City of Portland

Development Review Application  
Planning Division Transmittal Form

**Application Number:** 2014-098      **Application Date:** 06/03/2014  
**CBL:** 326 B009001      **Application Type:** Level III Site Plan Under 50,000 sq f  
**Applicant:** Allagash Brewing - 50 Industrial Way, LLC  
**Project Name:** Allagash Brewing Expansion  
**Address:** 50 INDUSTRIAL WAY  
**Project Description:** 2,400 Sq Ft Tank Support addition (Bunker), 18,360 sq. ft. Production Exp. (connecting 50 & 100 Industrial Way Facilities) adding loading docks and associated site work.  
**Zoning:** IM

**Subject:** Application ID: 2014-098

SHEET: C7.1

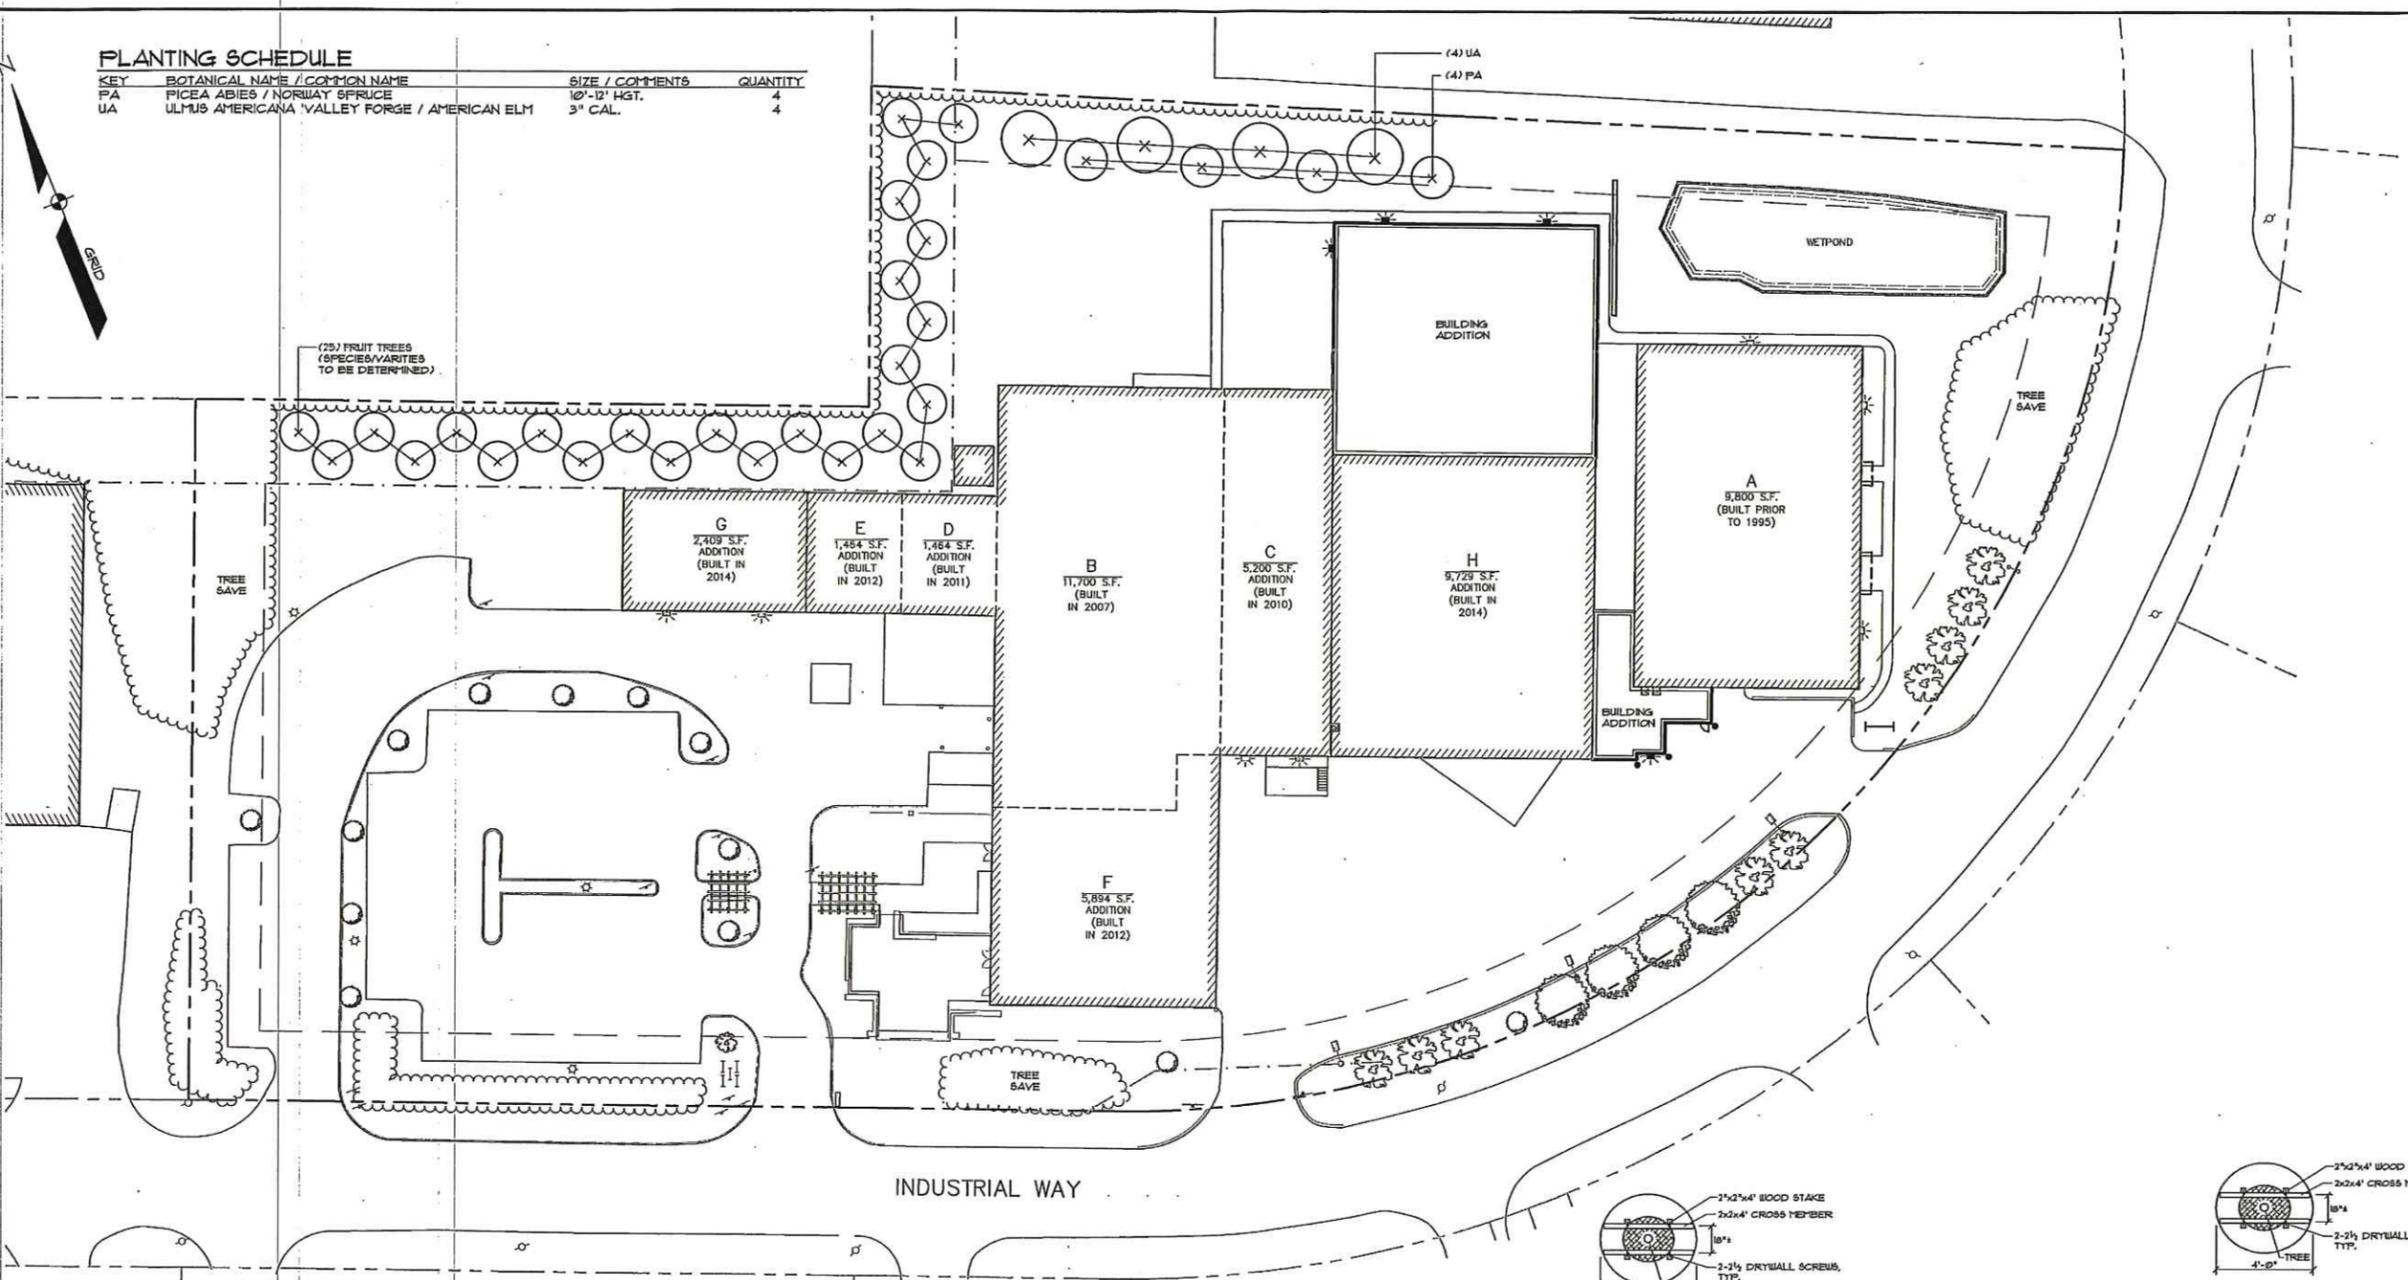
- The zoning administrator has commented (attached). She's asking for elevations showing building heights. Can you provide these by Thursday? That way we might avoid a condition of approval.
- Your most recent data sheet shows 10 existing and 10 proposed bike parking spaces. Can you confirm that you'll have 20 spaces total when finished? Can you remind me where the existing bike racks are?
- We need cut sheets for the exterior lights. If we can get these by Thursday, we might avoid a condition on this as well.
- The landscaping plan for phase 2 seems to show some trees in the detention basin. Can you take a look and advise?

- The proposed trees will be located partially on the side slope of the proposed basin. The stormwater management system (including the basin) is designed to drain stormwater runoff from the site in 24-48 hours. Therefore, the trees to be located on the detention basin's side slope will not have continually saturated roots.

NEW ADDITION LEFT ELEVATION

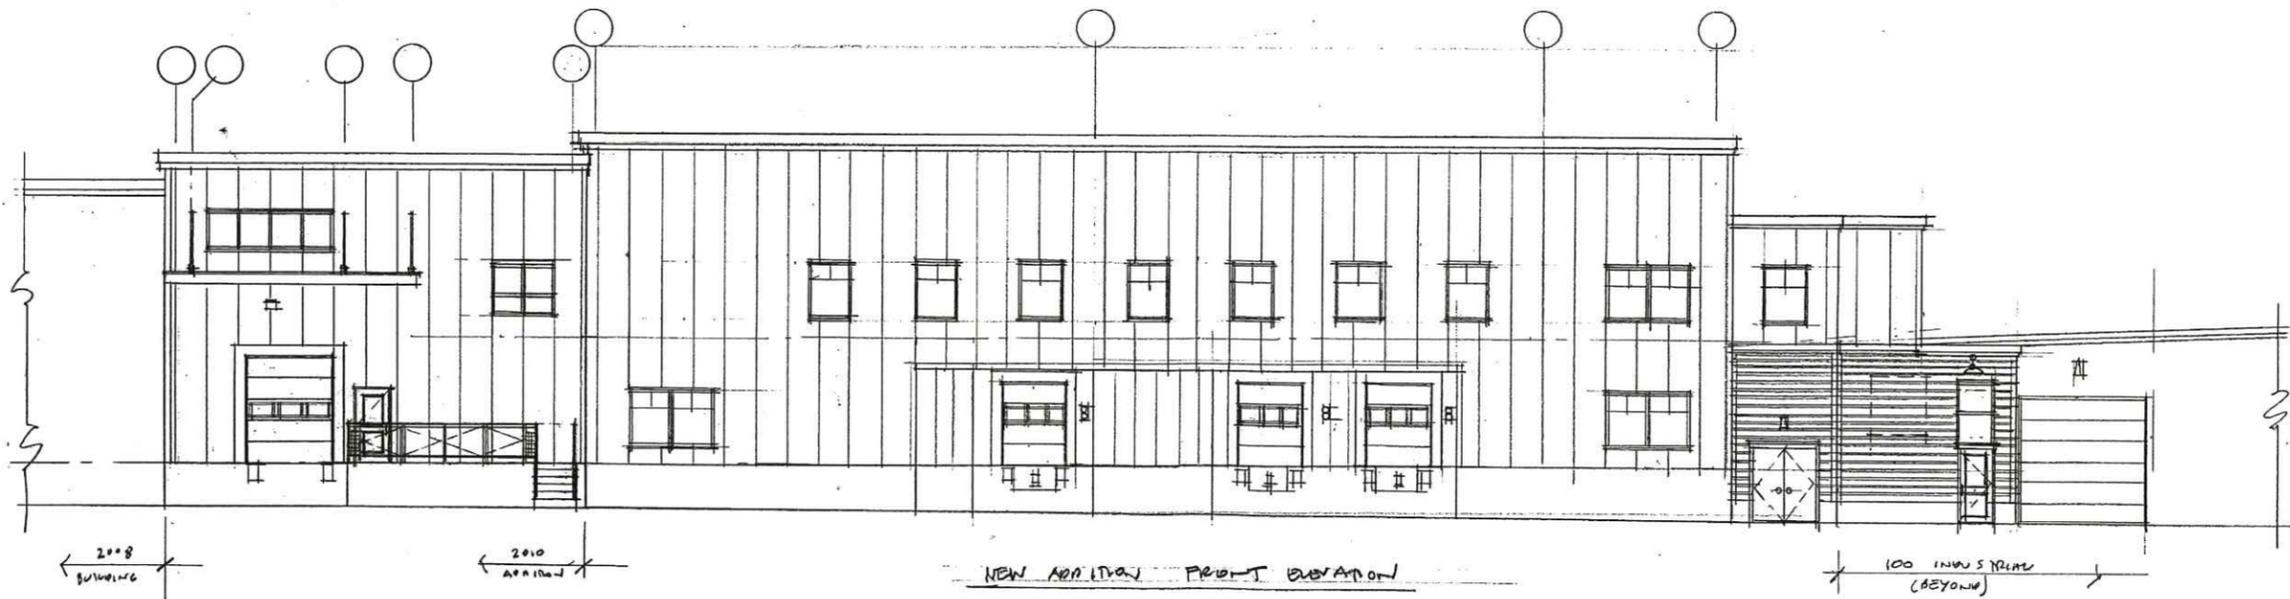
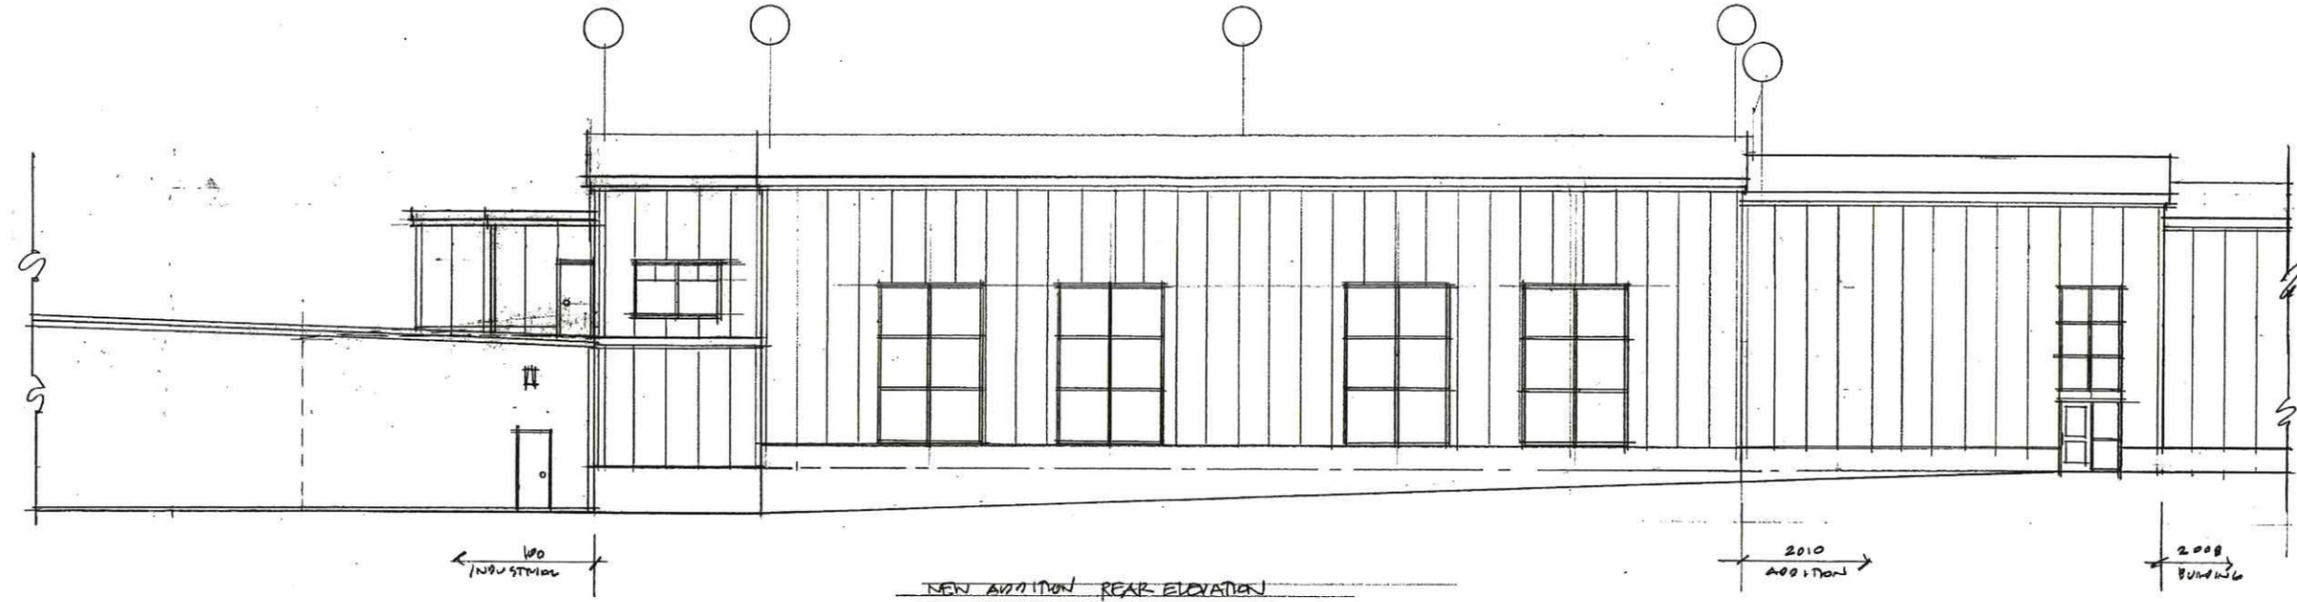
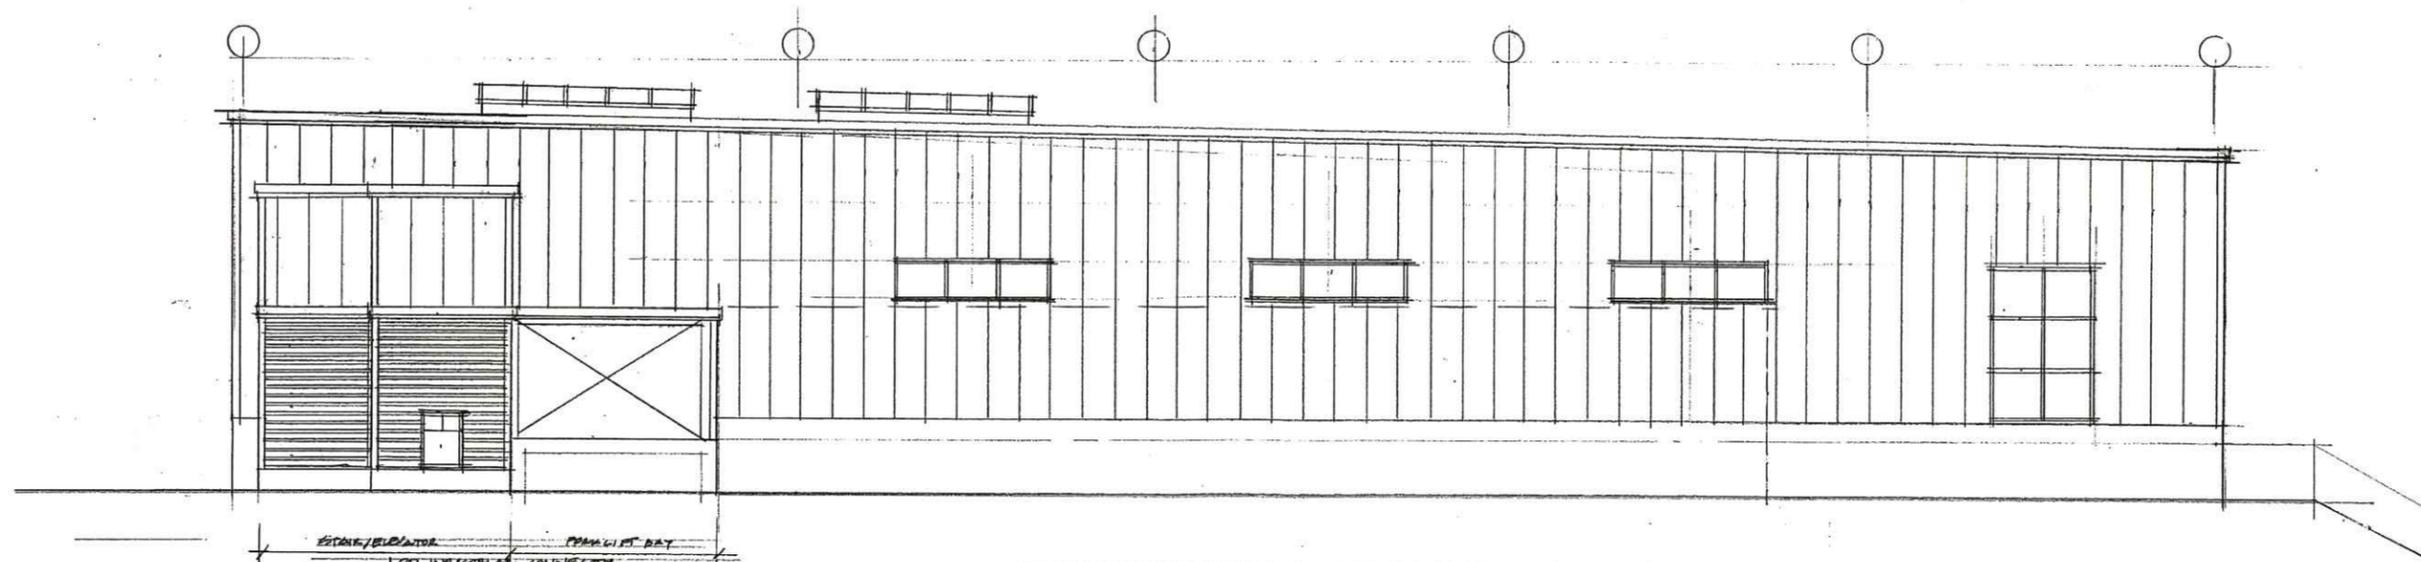
The newest additions to Allagash Brewery are meeting the I-M industrial dimensional zone requirements, including setbacks, impervious surface, and parking. The zoning analysis mentioned the height of the newest buildings as 31' or 34' depending on which set of given information is used. However the submitted building elevation page does not have any dimensions on it and does not have any scaling information on it. I am pretty sure the maximum height of 75' is not being violated. I will need an elevation plan to confirm the building height.

The applicant revised the zoning assessment sheet to reflect a building height of 34' which is well under the 75' maximum height. The building height also affects the required setbacks in this I-M zone. The I-M zone setback are being met using the 34' building height. The building permit #2014-01527 has been applied for and signed off for zoning at this time.

- The Architect is out of town this week. I'm not sure we'll be able to get you an updated elevation by Thursday. The highest (top of steel) elevation at the front of the new addition is 30.25' above finish floor. The average building height above grade is 34'. I've updated and attached the zoning narrative to be consistent with the height reported on the Site plan.
